REPORT UPDATE

Application No: AL/44/26/S73

REF NO: AL/44/26/S73

PROPOSAL: Variation of condition following the approval of AL/112/24/S73 relating to approved plans, access arrangements and visibility splays.

Site 9. Revised Vehicle Arrangements (Courtesy of Highways Statement)

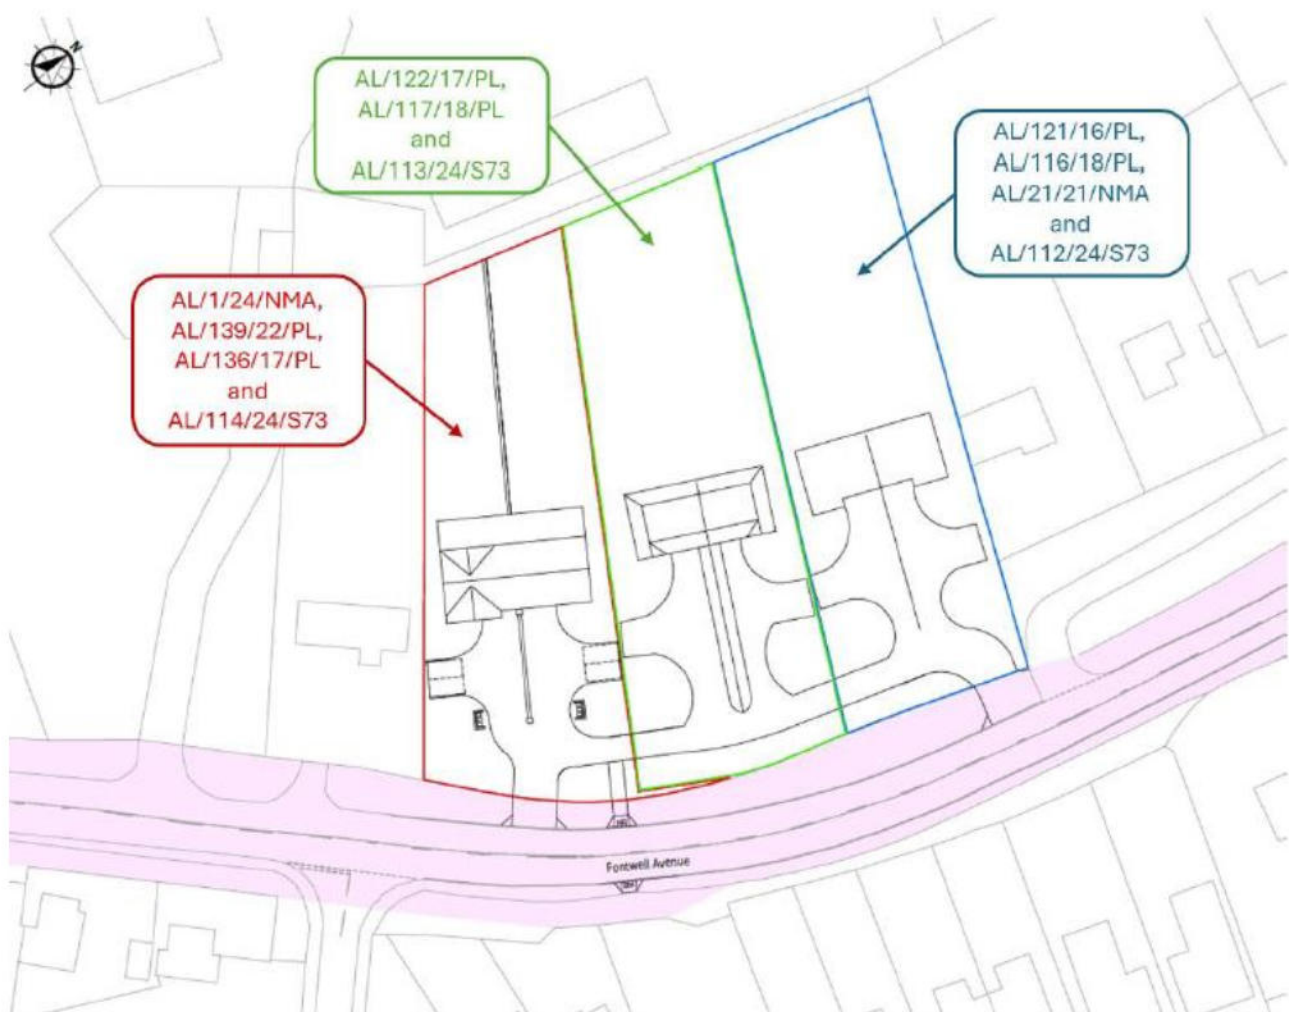
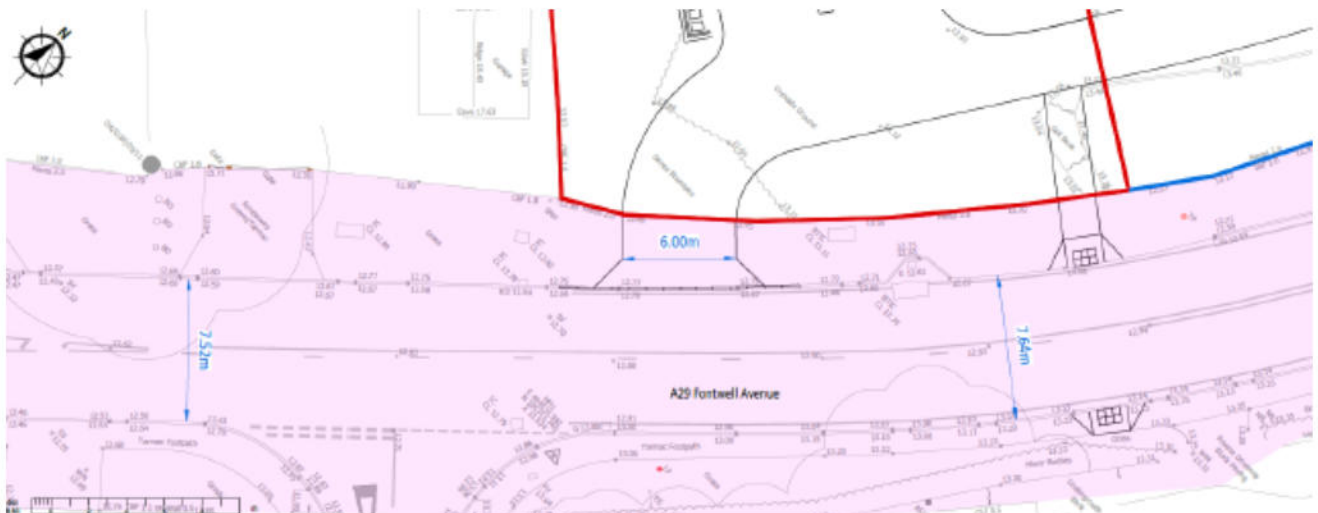
WSCC Highways - More Information requested. Vehicular visibility splays of 2.4m x 43m in accordance with 30mph speed limit have been demonstrated from the amended access location. In previous applications visibility splays of 59m had been provided and the Highways Statements state that splays in excess of 43m can be achieved. Require clarification of the previous 59m splay as these were likely secured due to actual 85th percentile speeds. Whilst it is acknowledged the posted limit is now 30mph, it would be useful for maximum achievable splays (within publicly maintained highway and applicant land)

to be provided whilst being mindful of any impact a greater splay may have on landscaping on site frontage.

The proposed access would replicate the approved (6.0m wide direct access, with 1.5m wide chamfers) but the southern access would be 8.5m further south to avoid utilities. Pedestrian access would be unchanged which is served from an uncontrolled crossing facility providing a link to the footway on the east side of the A29 Fontwell Avenue and this is sufficient to serve the six permitted dwellings. There is no conflict with ANDP policy GA2 as there is no loss of an existing pedestrian crossing point.

Comments noted. Visibility splays were provided and WSCC have been reconsulted. Comments awaited.

WSCC Highways requested an additional visibility splay. This has been provided and further comment is awaited. On the basis that splays are achievable and no objections were raised previously, it is not considered the alterations would result in harm in respect to road safety or capacity.
